City of Albuquerque Stormwater Construction Site Inspection Report

ESC File No.	K09E047	Project Name:	Southern Tire Mart		
NPDES Id. No.	NMR10044B/NMRNMR10043H	Location:	8201 Daytona Rd NW		
10/26/2021	Owner	Contractor			
Operator	Southern Tire Mart, LLC	Sparling Construction			
Contact name & title	Rick Yarbrough	Pat Wylie			
e-mail	rick.yarborough@stmtires.com	pwylie@sparlingconstruction.net			
Contact Phone #	505-917-6442	821-1034			
COA Inspector	Doug Hughes	Start/End Time:	4:30pm		
Construction Phase:	Vertical				
Type of Inspection:	<input type="checkbox"/> Regular	<input type="checkbox"/> Storm Event	<input type="checkbox"/> Past Storm Event >0.25"	<input type="checkbox"/> 311/Complaint	<input checked="" type="checkbox"/> Follow Up
Weather at time of inspection?		clear		Temperature: ~ 78	
Estimated date of last storm 0.25" or greater		9/30/2021

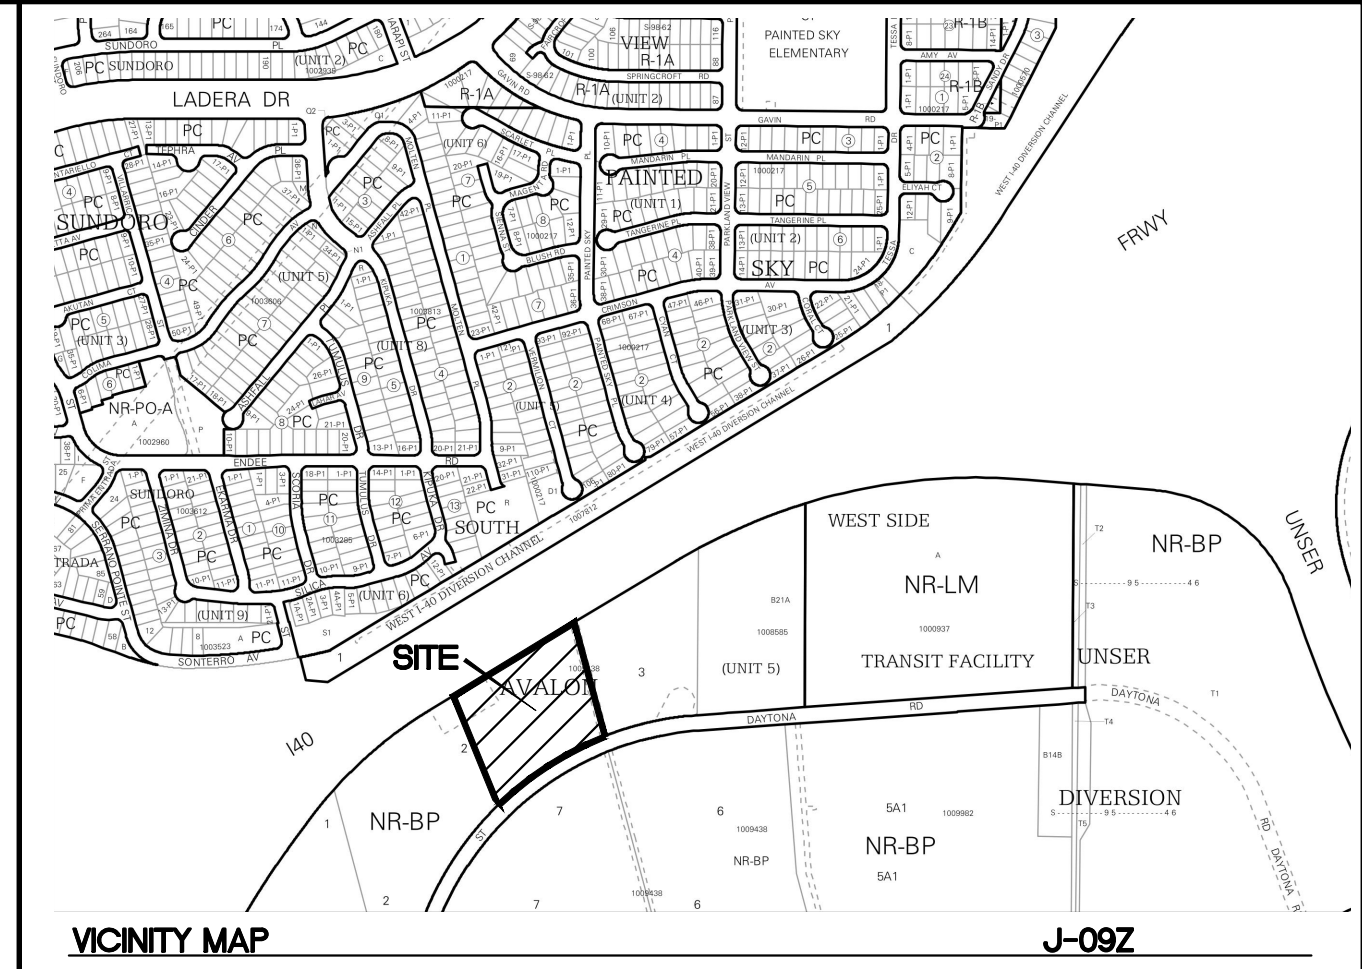
Item Number	Deficiency/ Corrective Action				
1	Up-to-date SWPPP not available onsite.				
2	Land disturbing activities outside of the planned area. A Soil disposal stockpile is in the SW corner, and a staging area is in the SE corner south of Daytona Rd. Update the SWPPP map is SWPPP and e-mail copy to me. Add BMPs and stabilization specifications for those areas of disturbance, and include in narrative description and schedule.				
3

Notes: Earthwork is complete all but fine grading. Utilities under construction in work order and onsite. Storm and SAS nearly complete. Additional silt fence needed around stockpile area southwest corner. Add offsite grading to limits of disturbance in SWPPP and stabilize inactive portion of site.
